From: [Thomas Siedler](#)
To: [Kelly Bacon \(CD\)](#)
Subject: Carey Mini Storage - Siedler Comments
Date: Tuesday, September 22, 2020 12:42:56 PM

We are immediate adjacent property owners (Thomas & Claudine Siedler) on the West side of the proposed Carey Mini Storage (CU-20-00003). We are submitting written comments for the record and requesting written notification of any actions or decisions.

# Site Plan

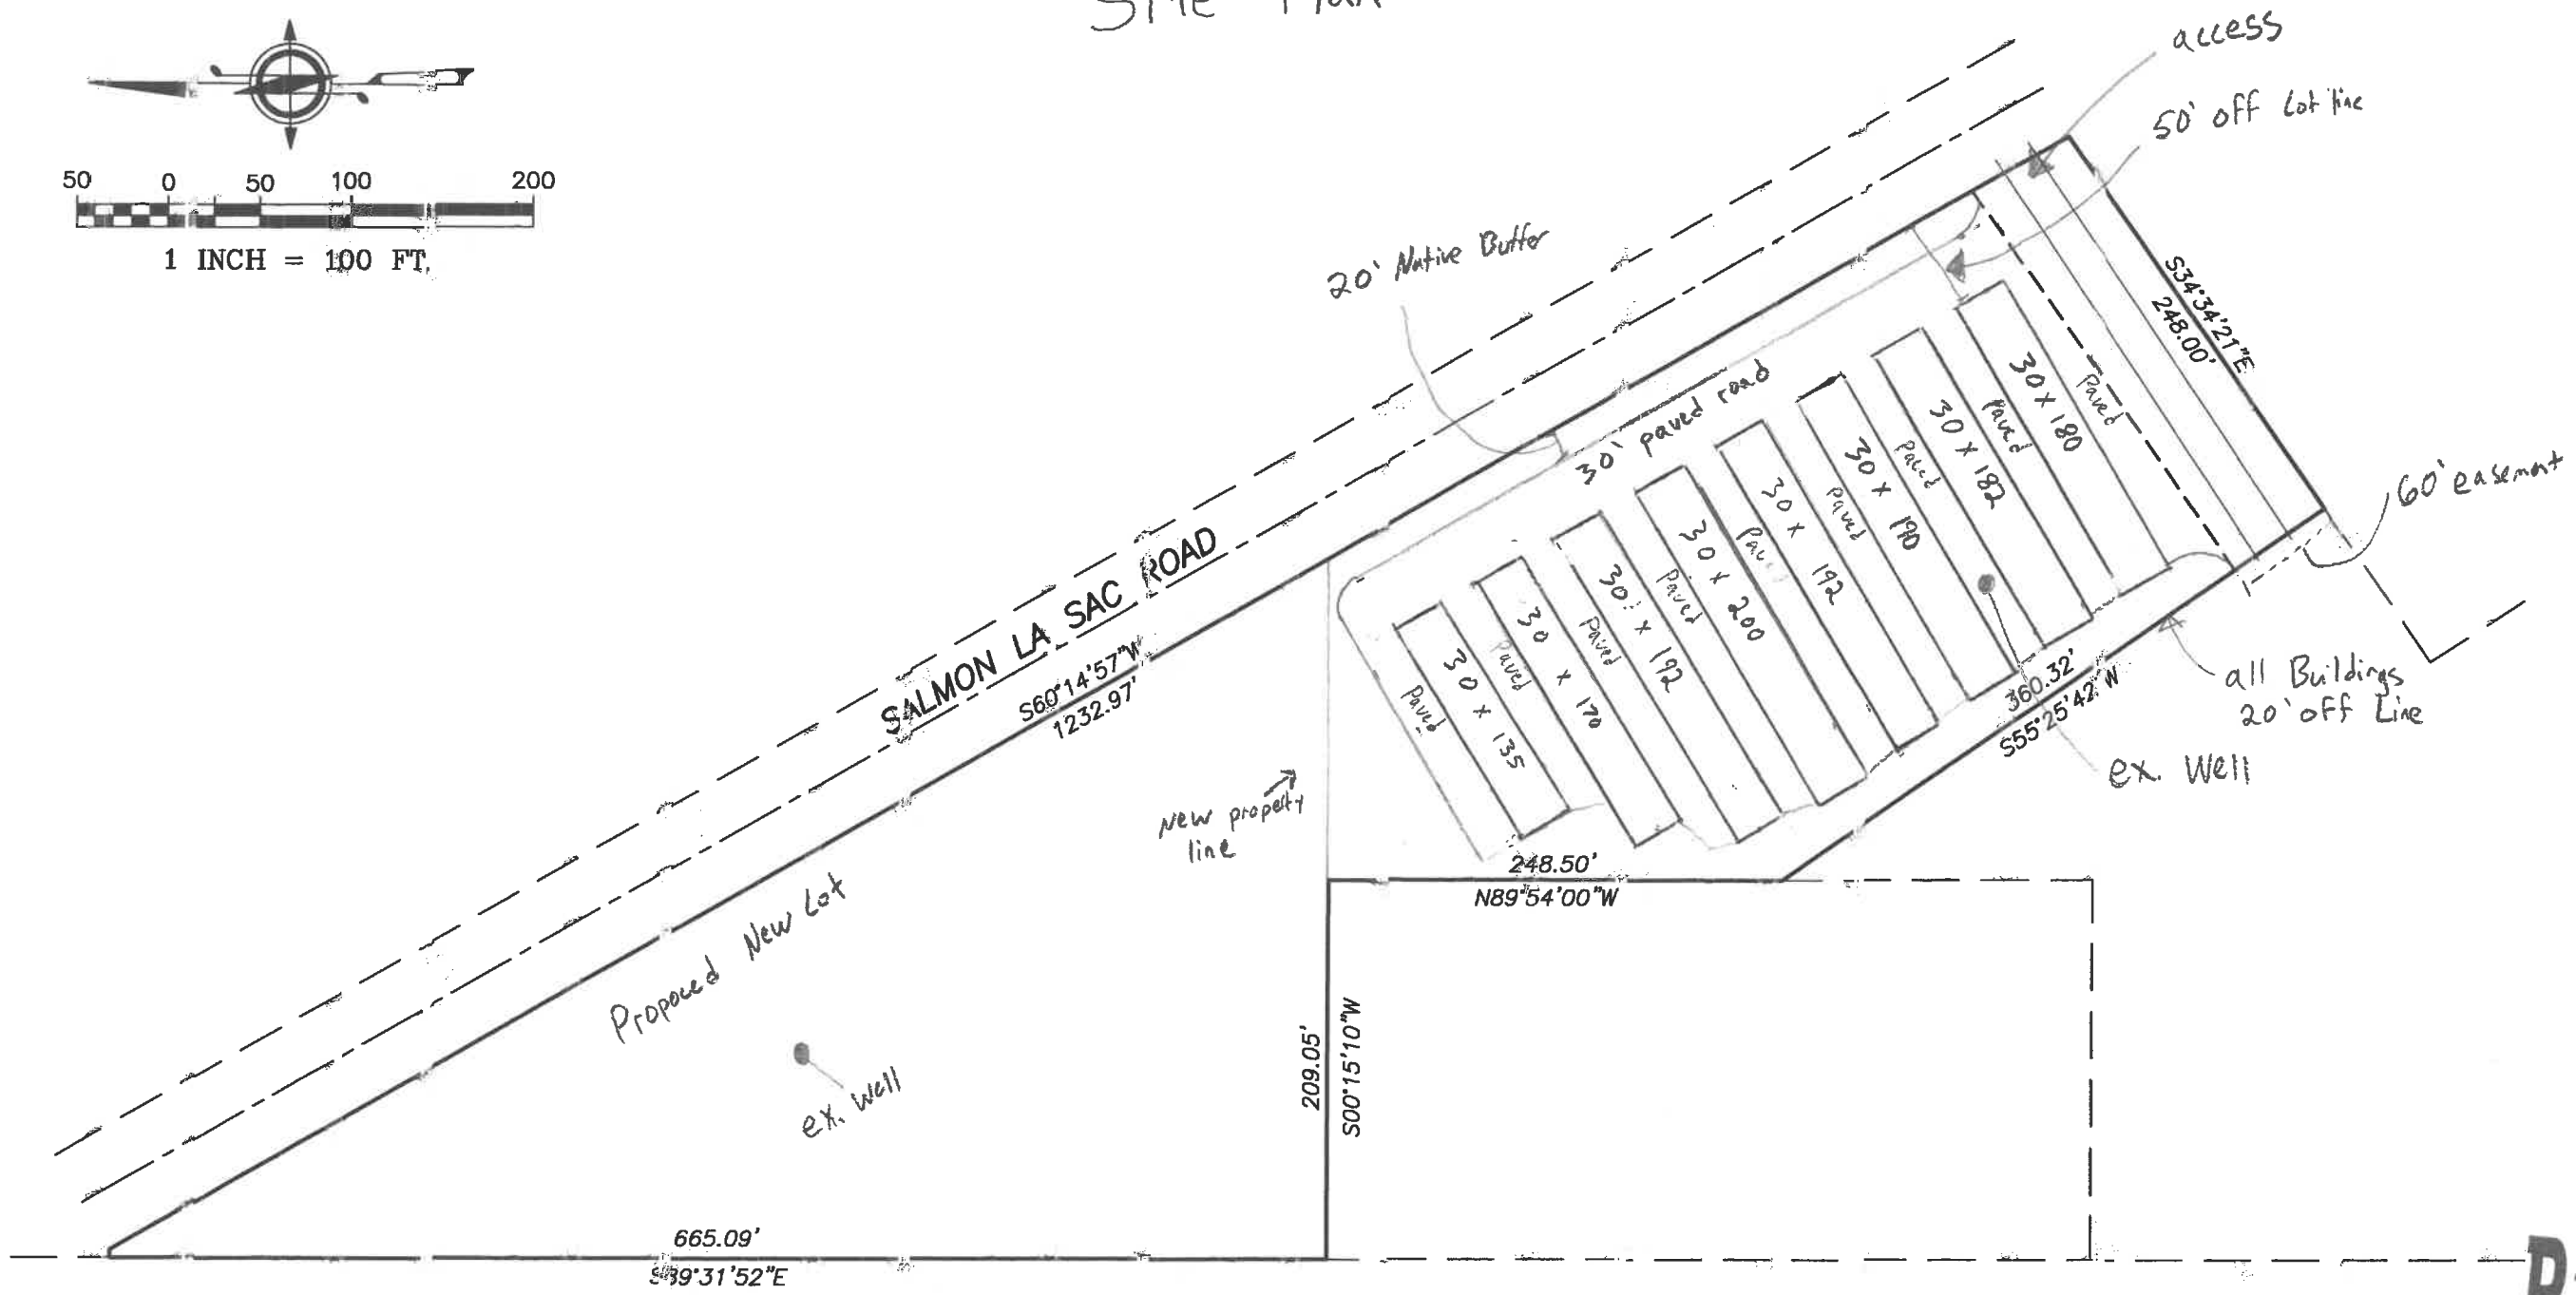
1. Impervious Surfaces – Applicant states that the project will cover 67,290 sf of the 130,680 sf site or 51%. I do not believe this is accurate given the proposed site plan submitted. The area of the Southern street easement needs to be excluded from the percentage and I believe the calculation itself is in error and understates the area covered. I would estimate the true impervious area coverage to be closer to 85%. This amount of coverage is inconsistent with the character of the area, may not meet code requirements and will cause drainage problems to our property, particularly during snow melt. Typically jurisdictions allow up to 60% coverage by impervious surfaces given an adequate drainage plan.

2. Water Drainage – The application does not contain an adequate water drainage plan which is described as “Sheet Flow with Spreader.” The native plant boundary on the East side of the property is only 20 feet which I am assuming is the filter area for the Sheet Flow. This amount is inadequate and should be 35 feet based on technical data I have reviewed. In addition it lies on the Uphill side of the property. We are downhill from the site to the West. No provision is shown for containing the water flows going to our property unless the whole site is regraded to divert water flows to the East which would be an expensive undertaking. In addition there is no filter area for the Sheet Flow on the South part of the site plan. An adequate drainage plan should be designed by a professionally certified drainage engineer.

3. Screening – As mentioned above this development is out of character with the adjacent land which is designated Rural Recreation. There is no mention in the application of screening of this commercial site from the adjacent recreational residential properties. This should be a requirement if the project is allowed to continue. I would recommend a 10 foot fence that is rustic in nature with visual barriers and consistent with the recreational setting. The applicant states that they will be leaving natural native vegetation as a boundary separator. It should be noted that vegetation is sparse and slow growing in the boundary 20 foot setback since this was at one time a pasture.

4. Density - The application indicates there will be 9 buildings on the site with the area between buildings paved. The height of the buildings is to be 25 feet. This is **extremely high** given the rural recreational nature of the area. There is also no need to build this to a height of 25 feet which is also out of context with the neighborhood given the large number of buildings proposed.
